Your ref: 3/2017/0294 and 0295

Date: 23rd May 2017

Planning Applications 3/2017/0294 and 0295: Conversion of former Punch Bowl Inn into five holiday lets and cafe including demolition and extensions. Creation of new caravan park with fifteen units; Former Punch Bowl Inn, Longridge Road, Hurst Green BB7 9QW

GROUND FLOOR PLAN AS EXISTING

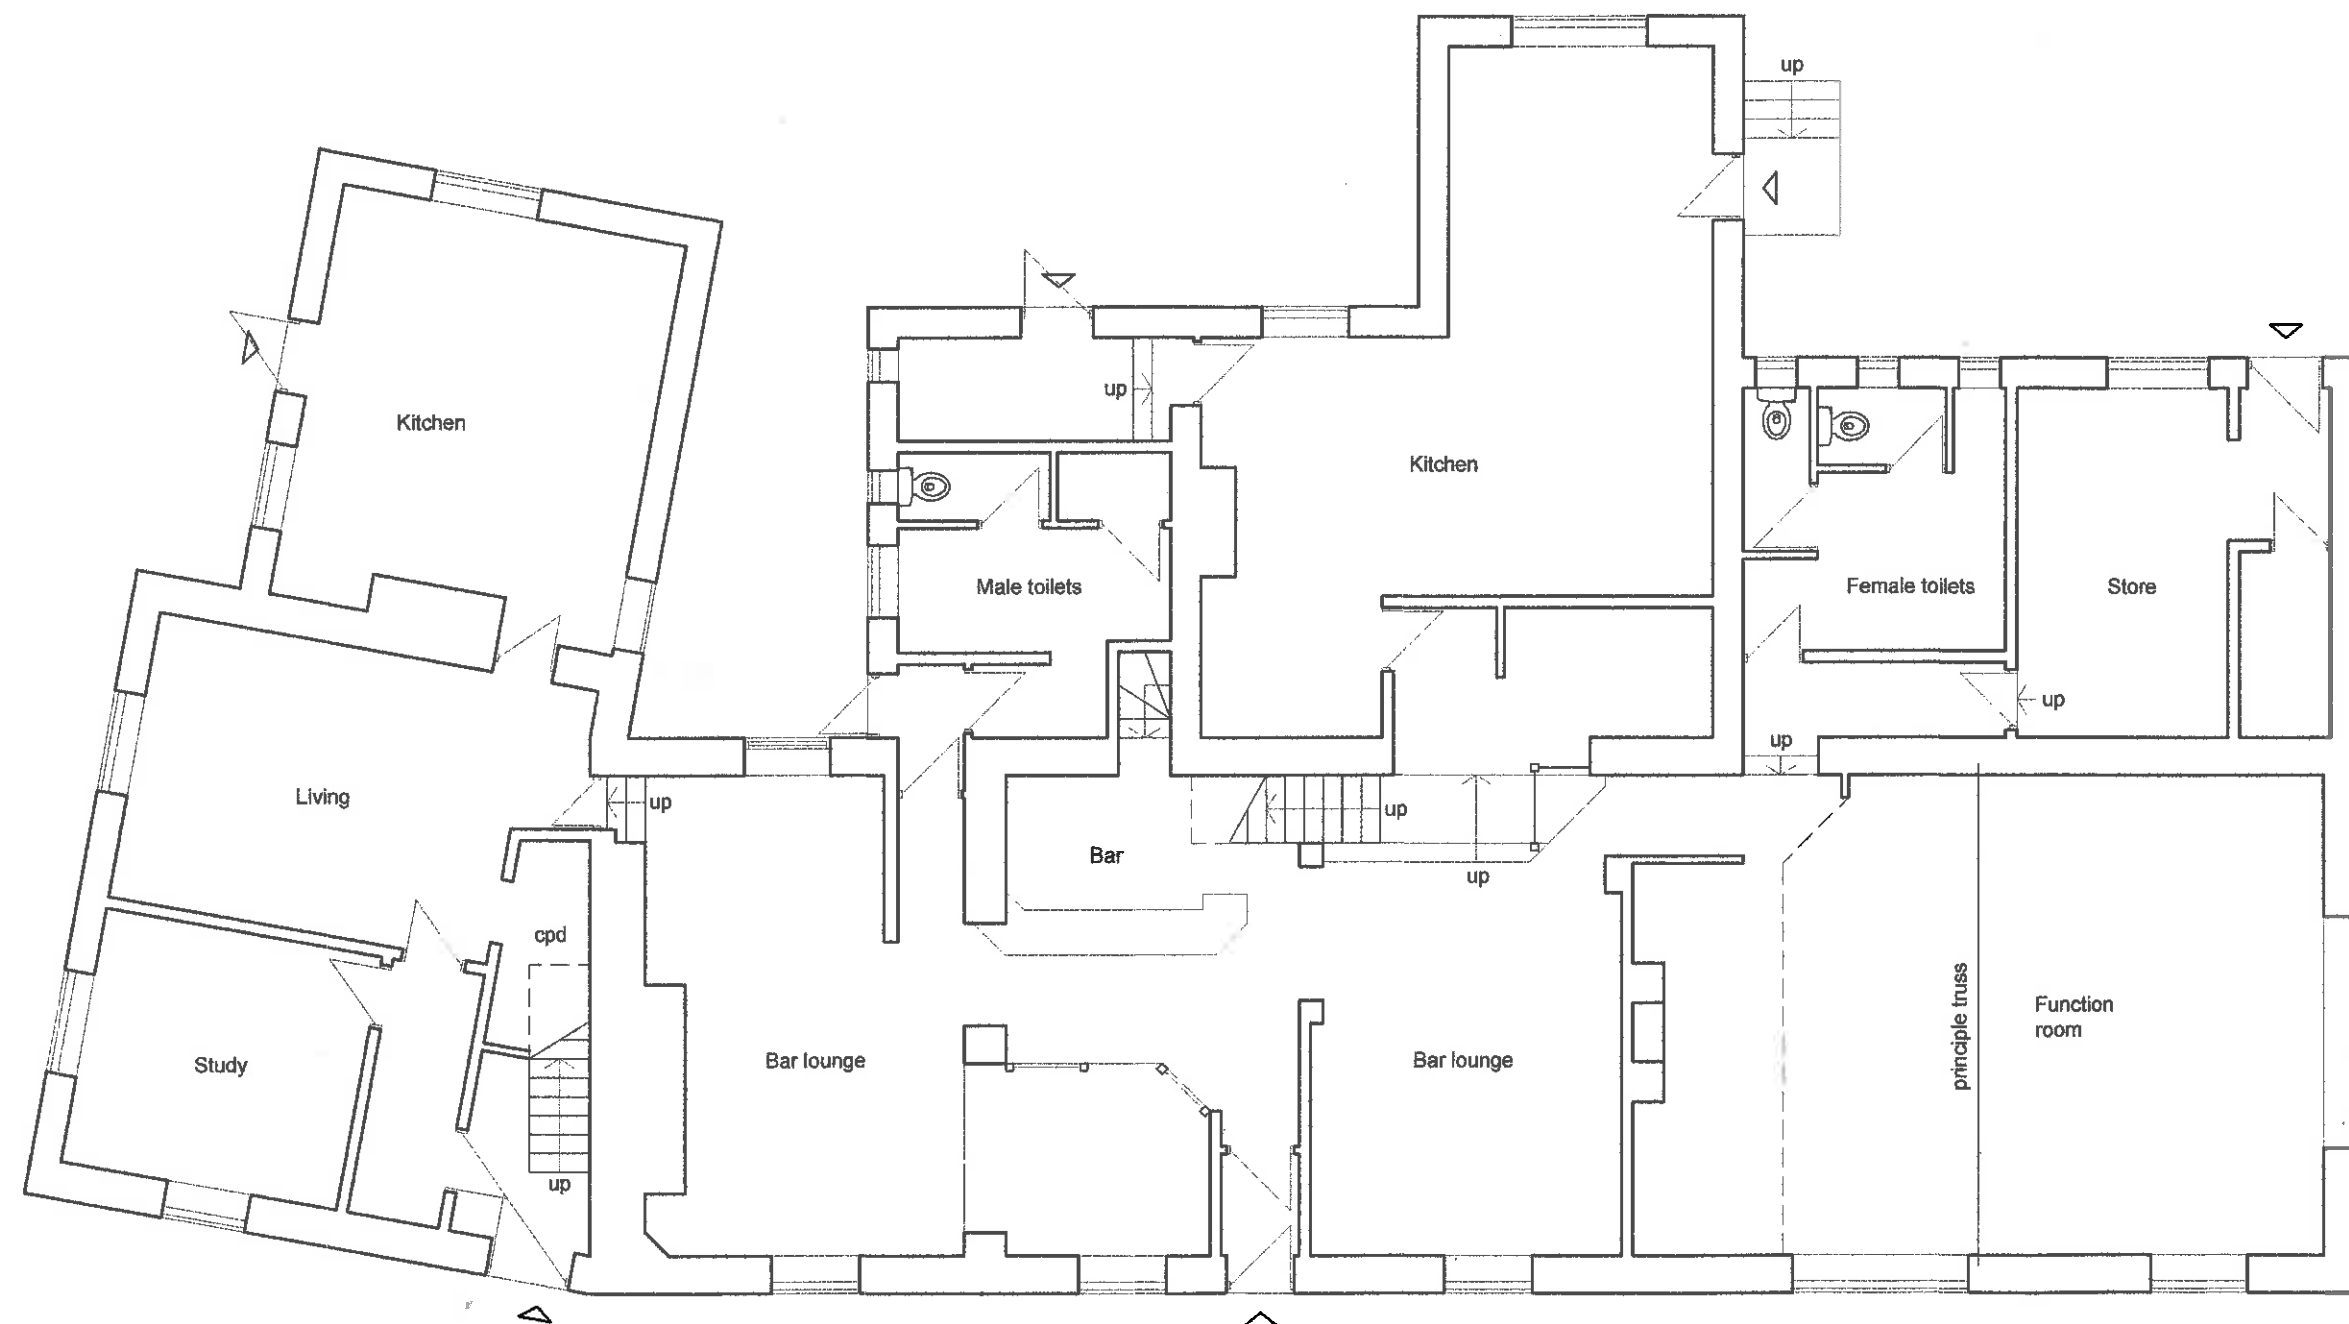
- (i) The loss of the rear barrel vaulted cellar (unless this can be shown to be modern);
- (ii) The loss of much of the rear wall of the right-hand former barn section and partial demolition of the outshut under the catslide roof; and
- (iii) The loss of the rear stair in the former cottages and the subsequent changes to the circulation pattern.

Of these only item (iii) is mentioned in the Heritage Statement "*The staircase running up this wall is probably not original or in an original location and has been entirely destroyed by dry rot*". Examination of the plans 'as existing' provided with the application would support the suggestion that this stair is a later insertion as it appears to bridge the space between the two original cottages. It seems possible, perhaps even probable, that this change would have been associated with the original conversion to an inn, and thus pre-dates 1847. It would have been helpful if further description and photographs of the stair had been provided and/or that the date of the stair and its state of repair could have been assessed.

Item (i) is not mentioned in the Heritage Statement, but the cellar is noted in the Structural Assessment (Norman Williams Partnership, nd, p.2) and its date is unknown – although it seems probable that the 1847 inn would have needed such a cellar. It is not clear if the intention is to completely demolish and infill the cellar, which sits under the rear kitchen extension, or if it simply to be cleared to ground level. If the former is proposed, then this needs some further investigation, description, impact assessment and justification. If the intention is simply to remove the above-ground access to the cellar and to carefully pave over its entrance stair, retaining it intact, then this will need less investigation and justification but will require a method statement for the demolition and covering-over.

We would therefore recommend that some further information is obtained from the applicants before the application is determined. This should include a more thorough assessment of the elements of the building to be altered or repaired and the impact of

the proposals upon them. Further details of the rot and other damage to the building and the extent of repair works to the historic fabric required should also be provided.

PROPOSED GROUND FLOOR PLAN - REV C
SCALE 1:100 @ A3

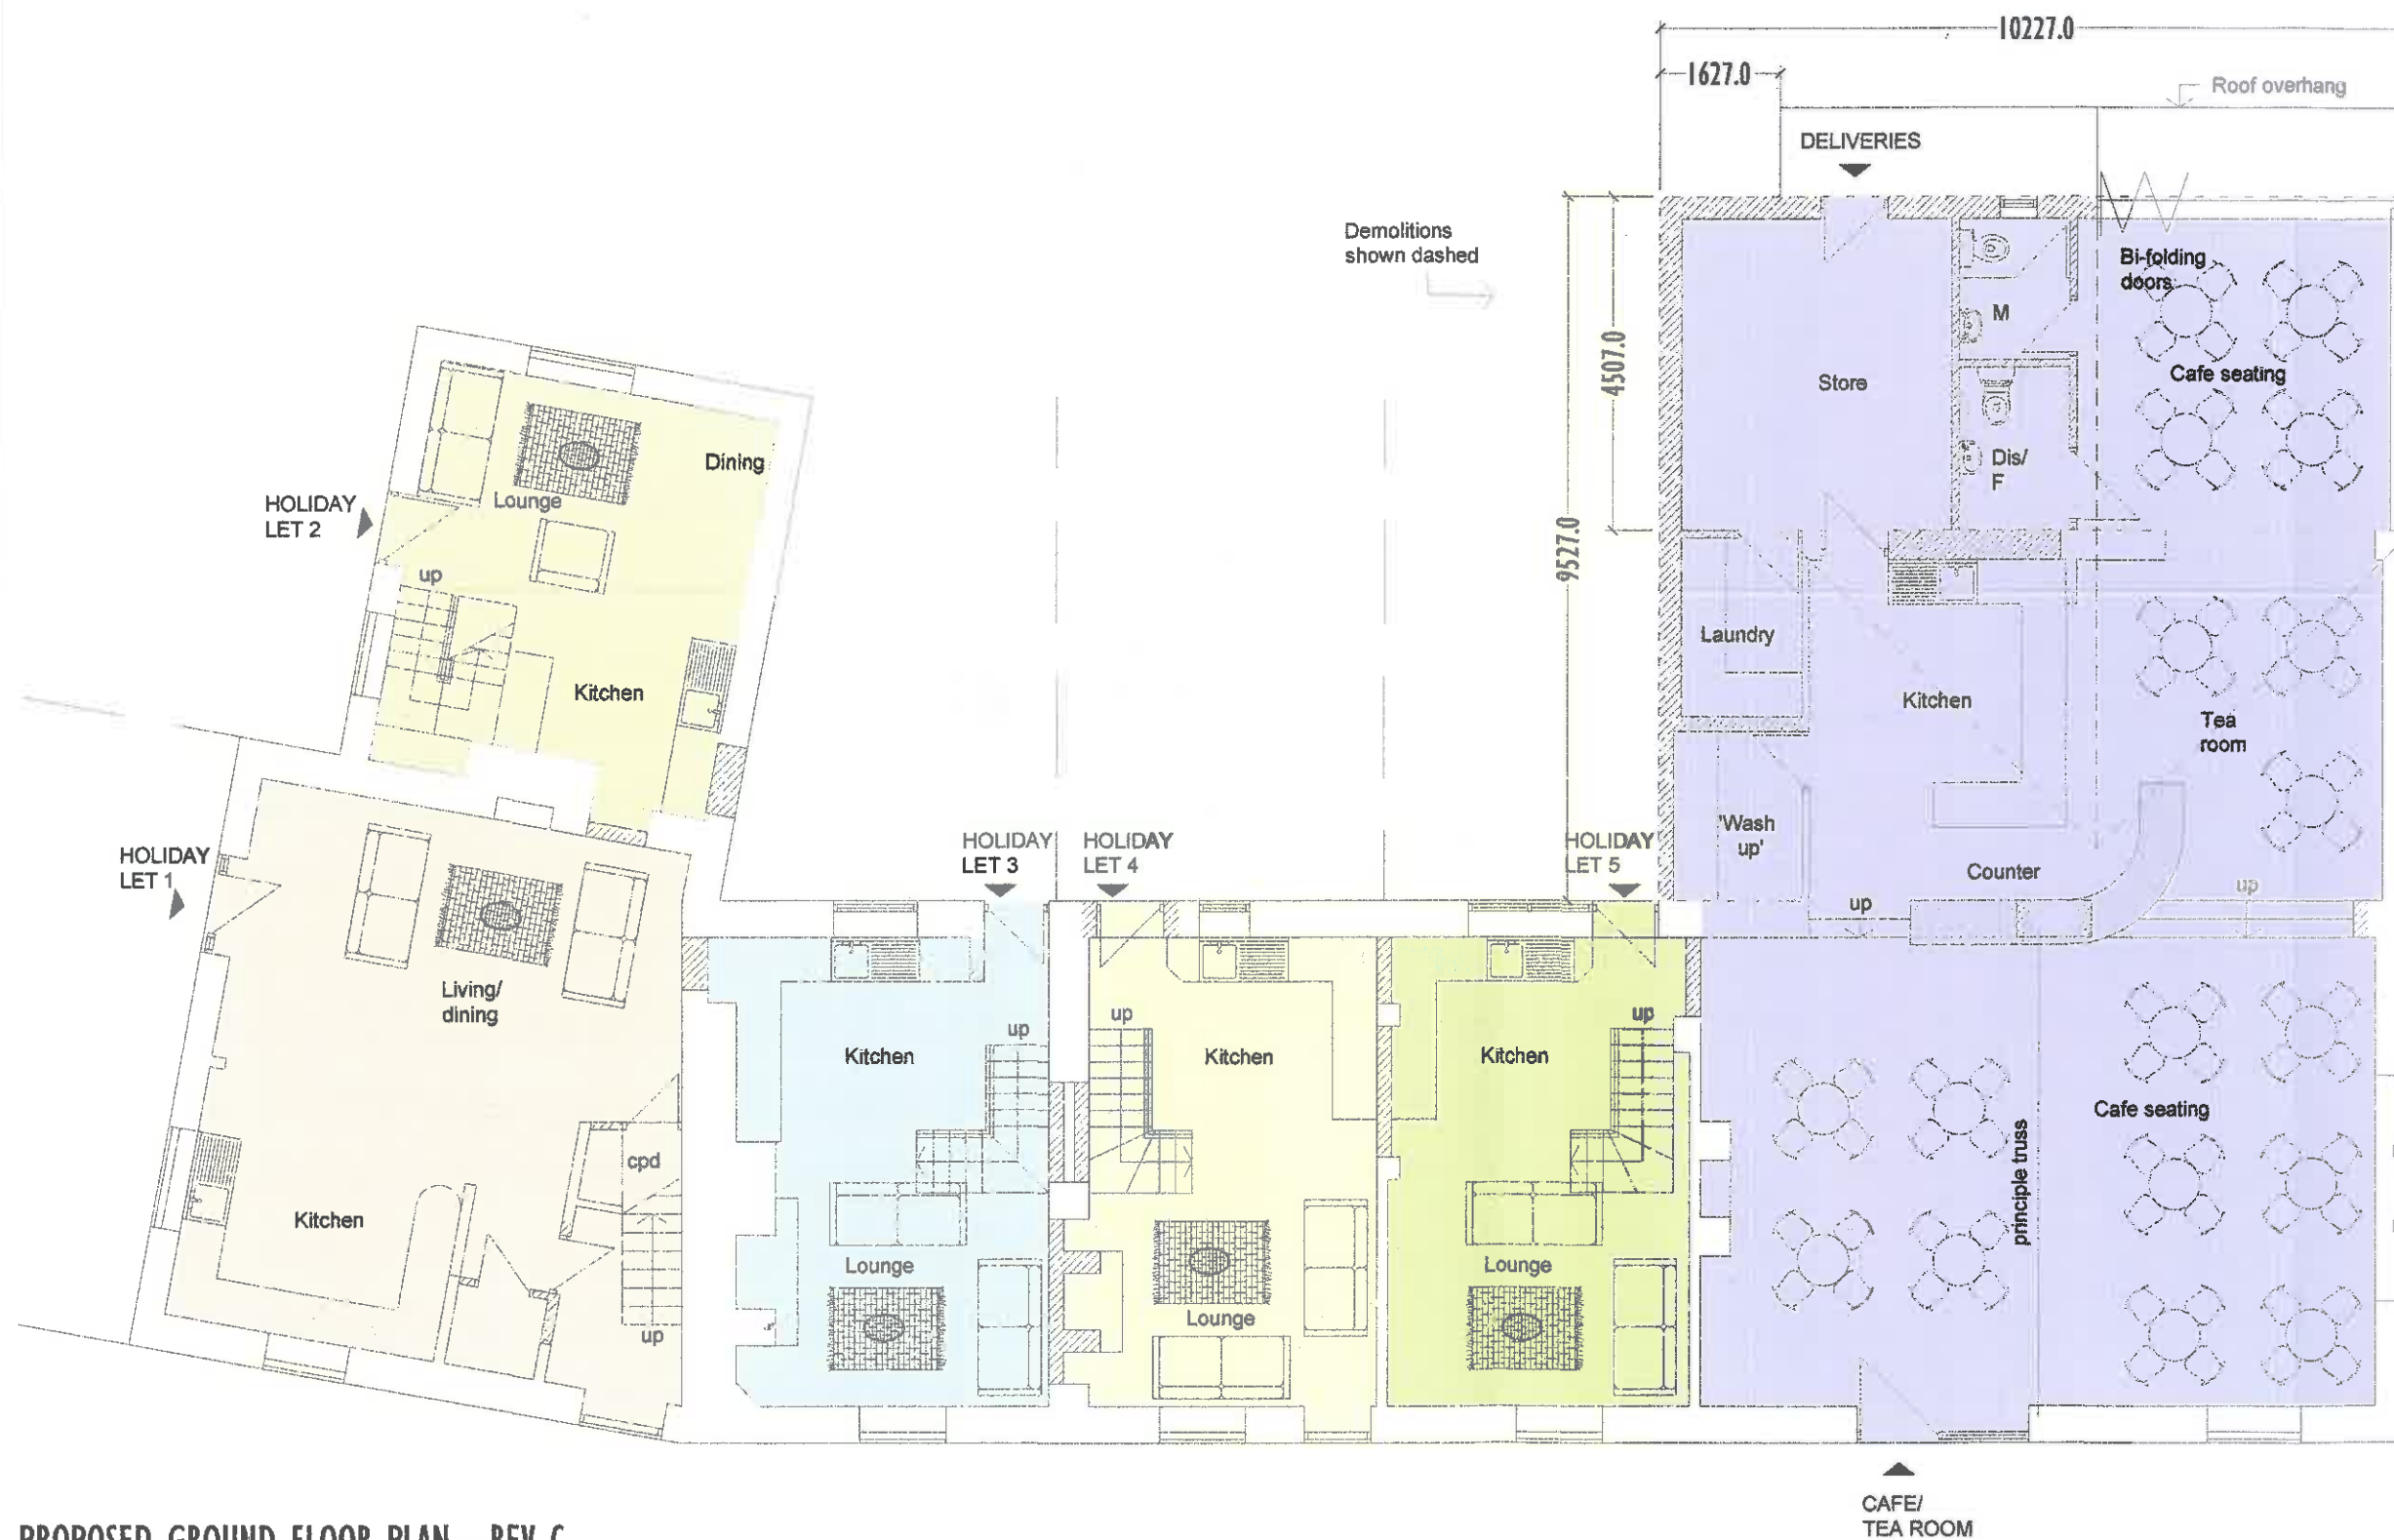
Similarly the removal of the rear wall of the 18th century barn is not mentioned in the Heritage Statement, nor is the impact of this work assessed except perhaps in the statement "*The existing 'original' rear wall of the range of buildings has only one surviving original feature...*" The rear outshut to the barn, covered by a catslide roof, is also not described or discussed, although it would appear to be present on the OS 1847 map.
